From: clerk@wiswellpc.org.uk
Sent: 07 February 2023 15:10
To: Planning
Subject: Consultation on planning application 3/2023/0032 Fair View, Pendleton Road, Wiswell BB7 9BU

Good day,
Comments on the above planning application.

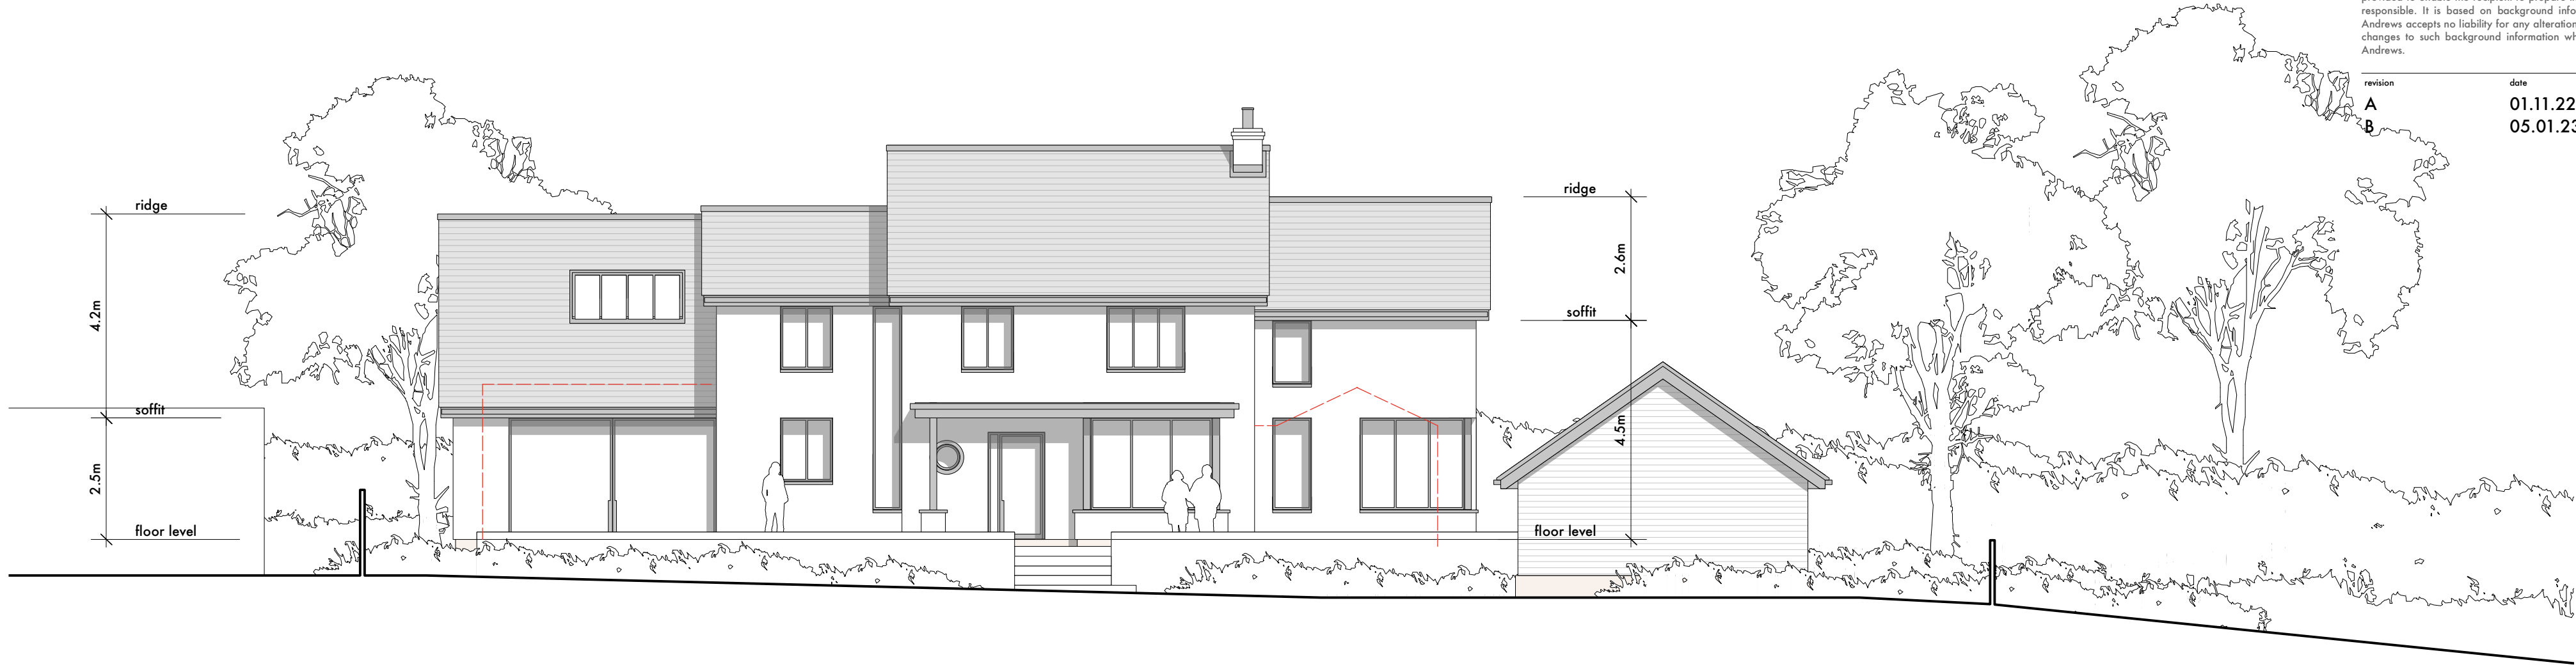
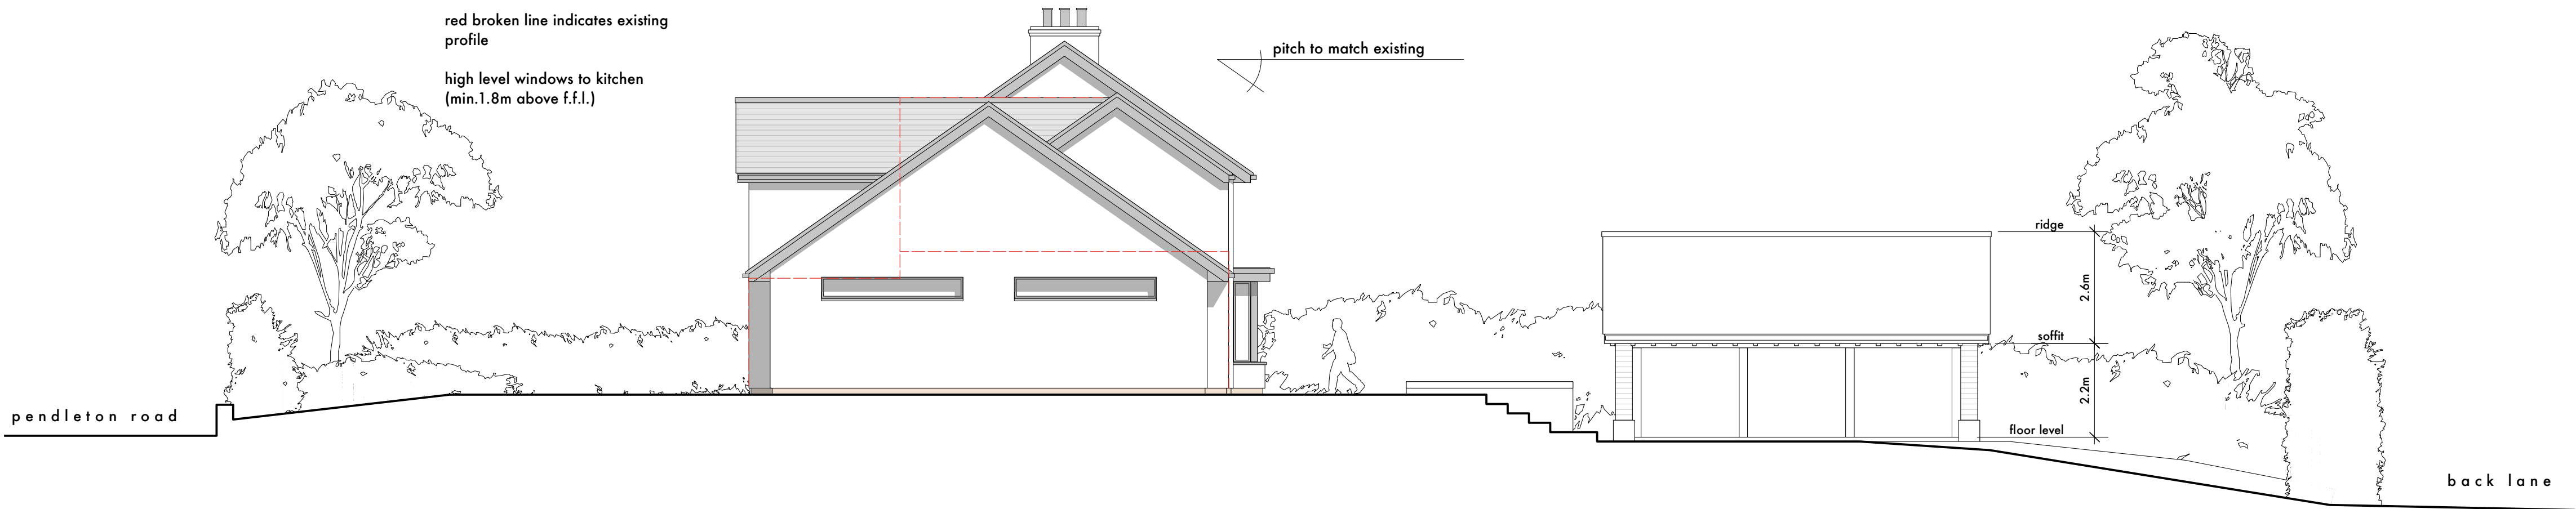
- This property has been extended several times and this proposal will improve the overall appearance and eliminate the flat roof areas.
- There does not seem to be a definition of level for the garage block in relation either to the road surface or to the existing house. This is essential to control the visible height which is a relatively significant addition in the Conservation Area.
- To avoid reversing out onto Back Lane (with the poor visibility), it should be confirmed that there is a sufficient turning area is maintained on the drive.
- The heights of the hedges facing Pendleton Road and Back Lane are not shown accurately on the elevations. They are significantly higher than shown, particularly on Back Lane. Does this mean that it is proposed to reduce the hedges to the height shown? There is currently loss of light for properties on Back Lane.
